Case Officer: Hansah Iqbal

Recommendation: Approval

Proposal: Incorporation of louvres, metal double doors, colour and finish to match adjacent, extension of external plant area, finish and materials to match existing, two new windows (proposed as non-material amendment to 22/01632/REM)

## Existing Building Elevations Alterations

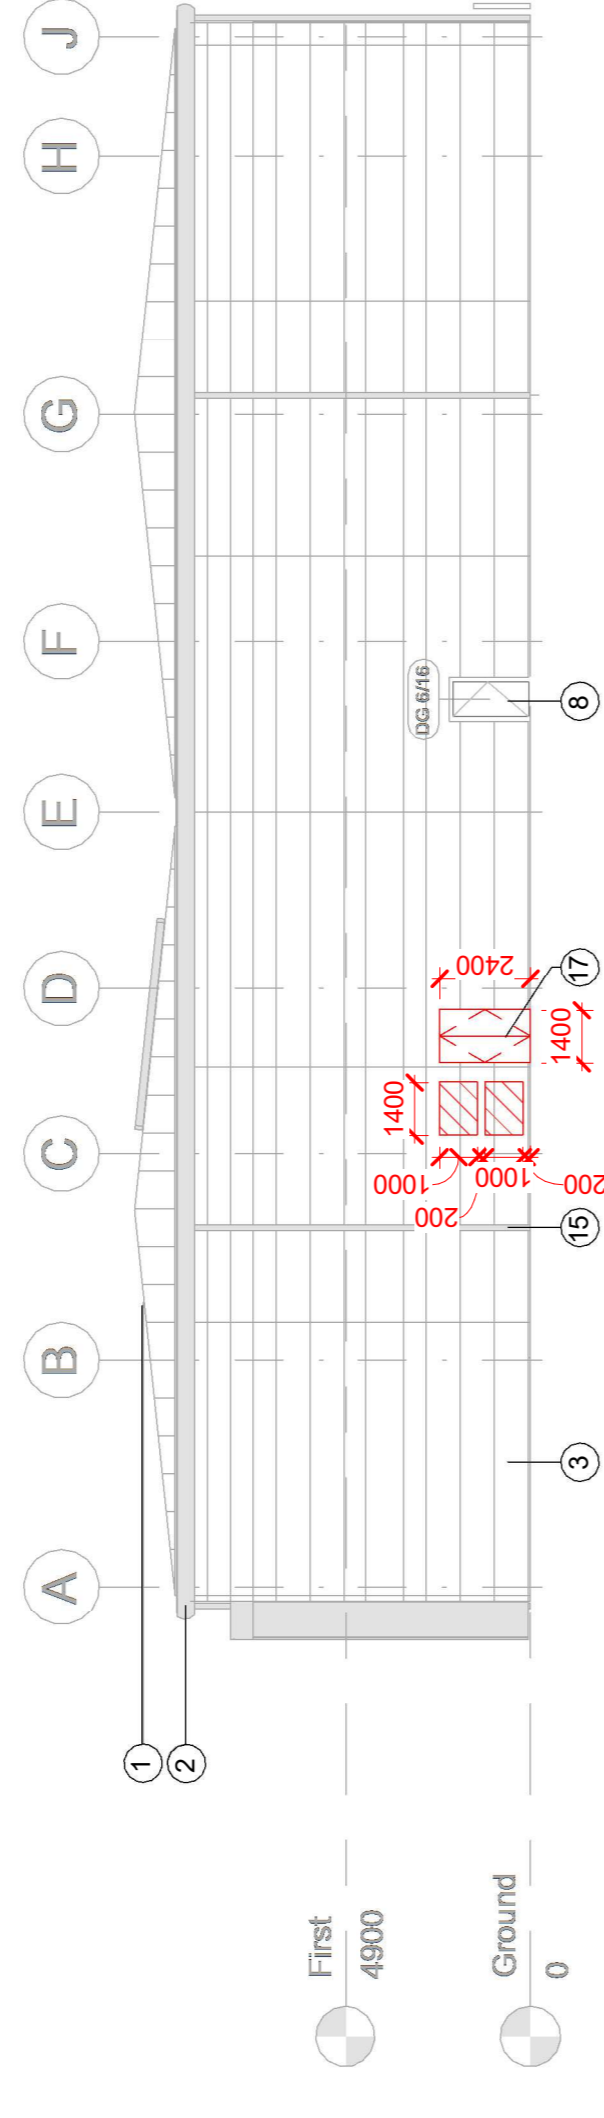
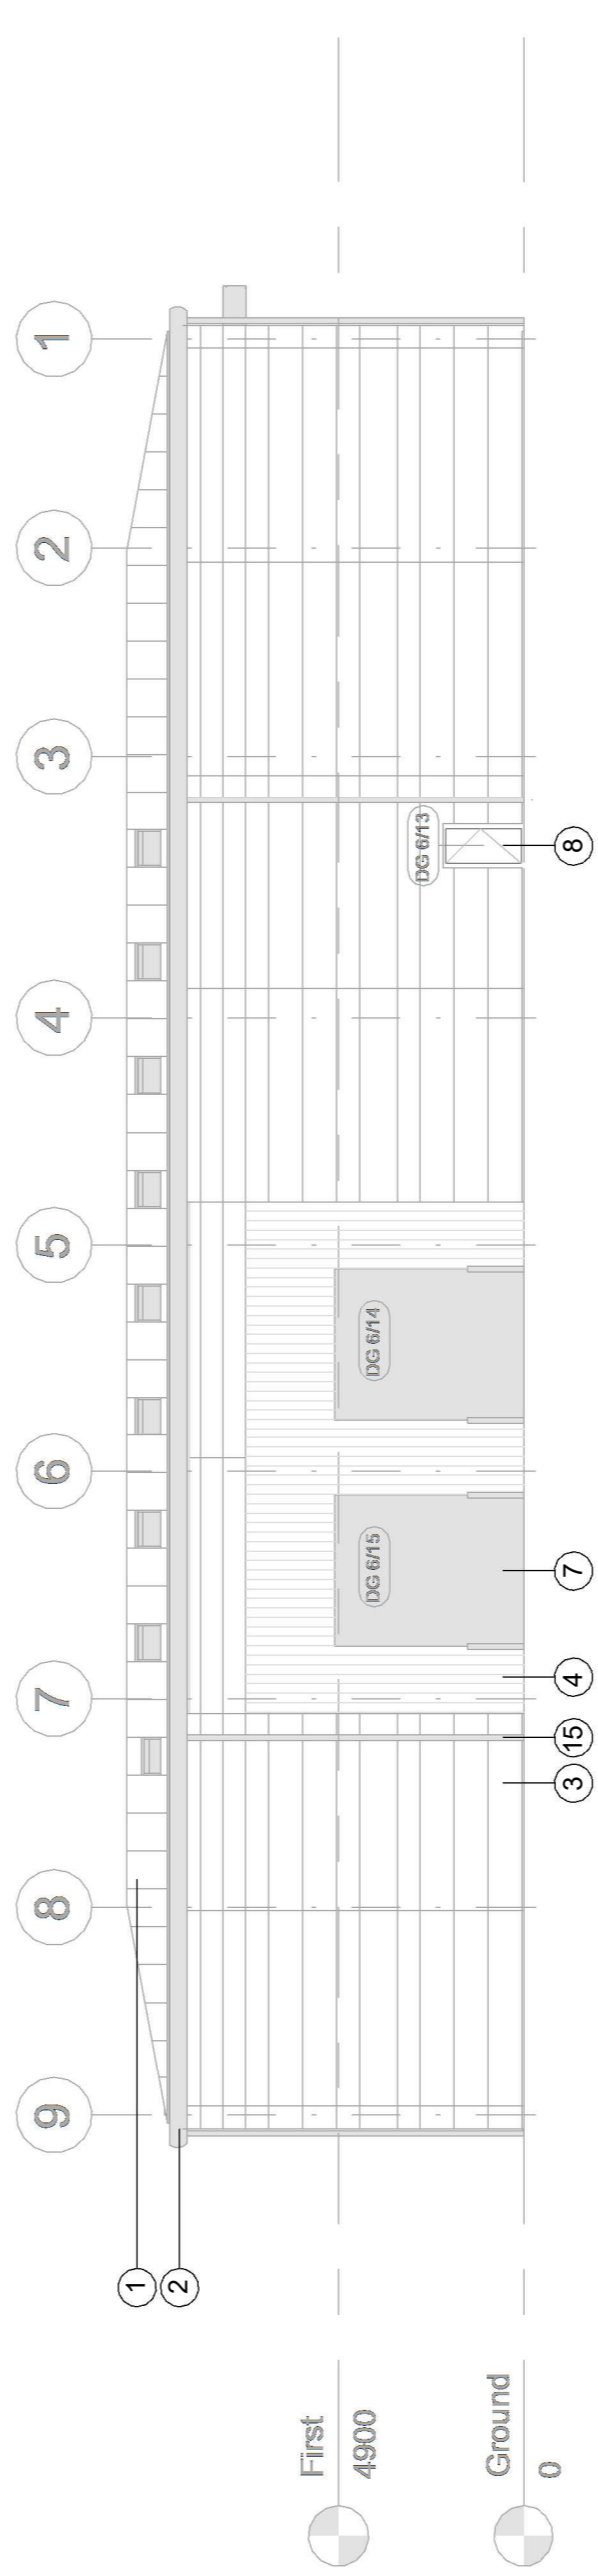
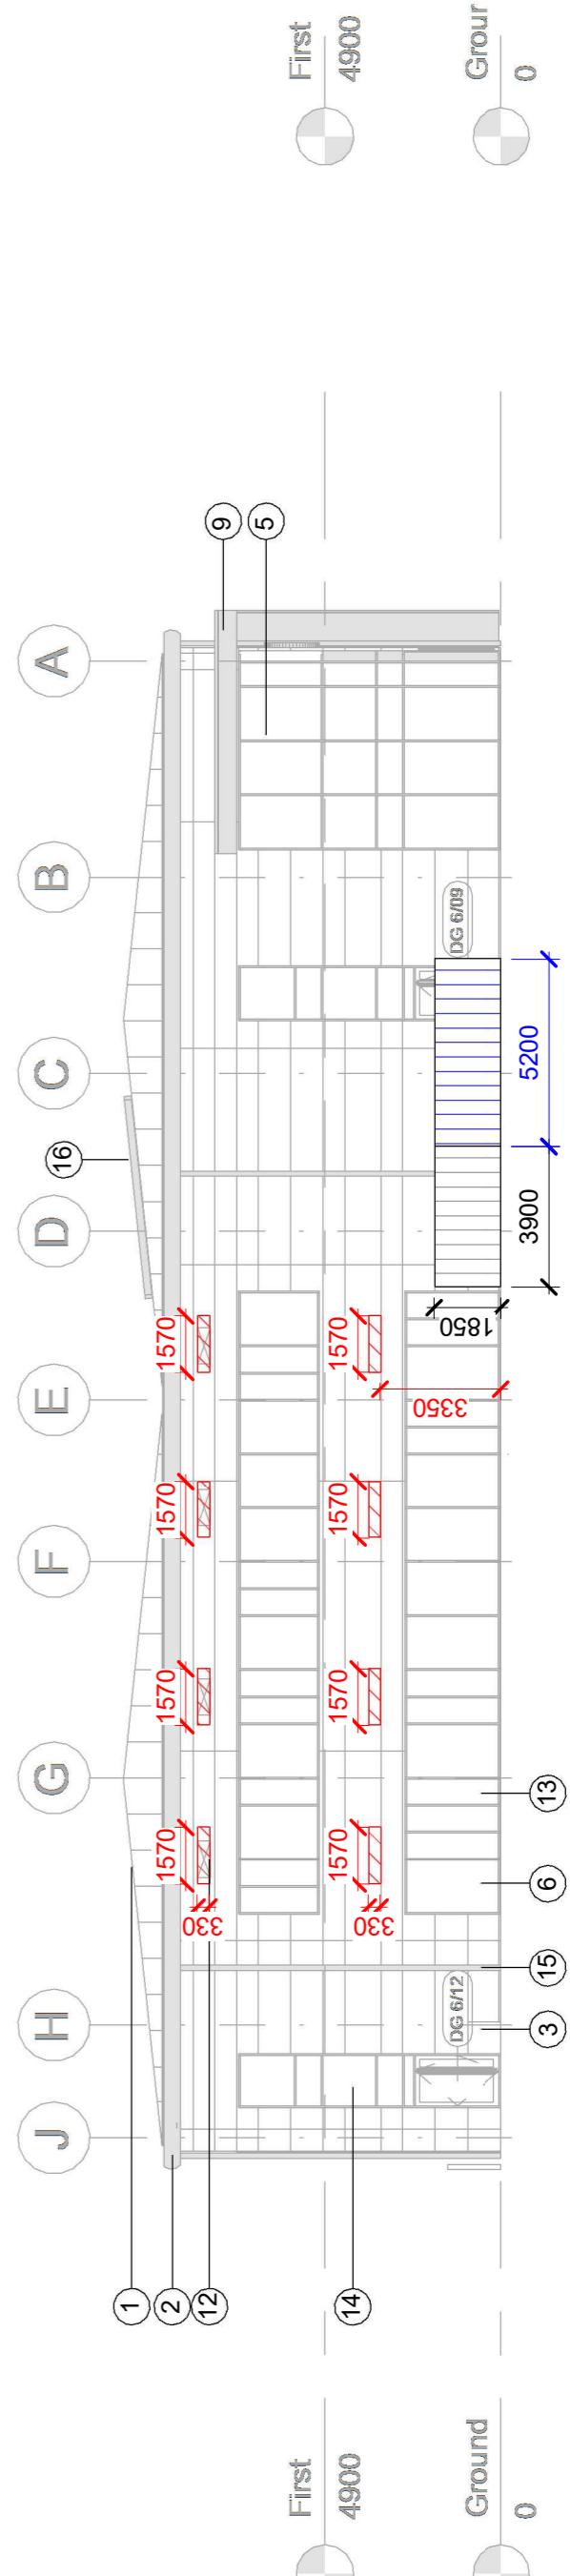
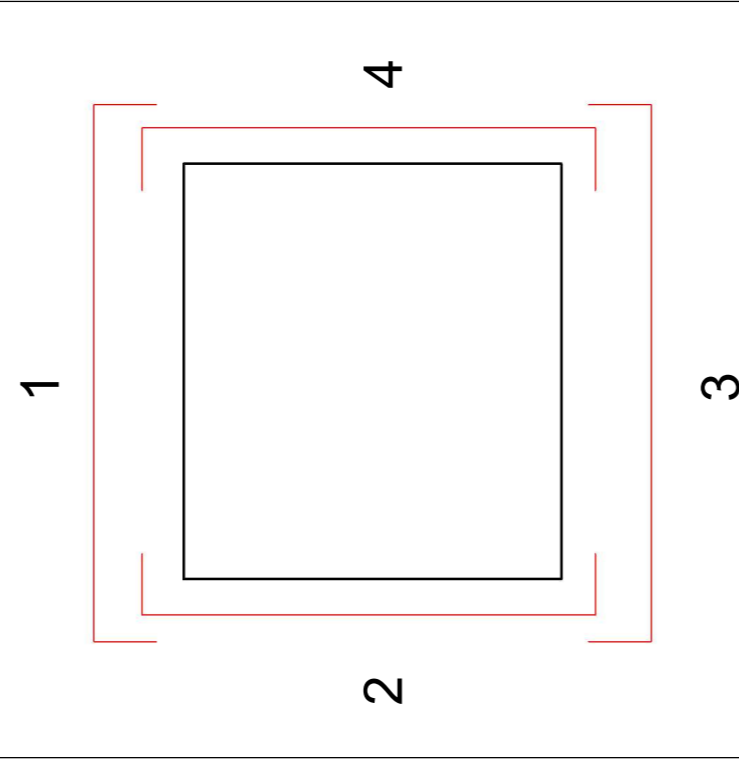
The installation of additional louvres would be on two elevations where louvres have already been approved. The additional number would therefore be acceptable. The new door and windows would be on the side elevation, and would be largely screened from the public domain therefore not having a significant impact on the character of the streetscene.
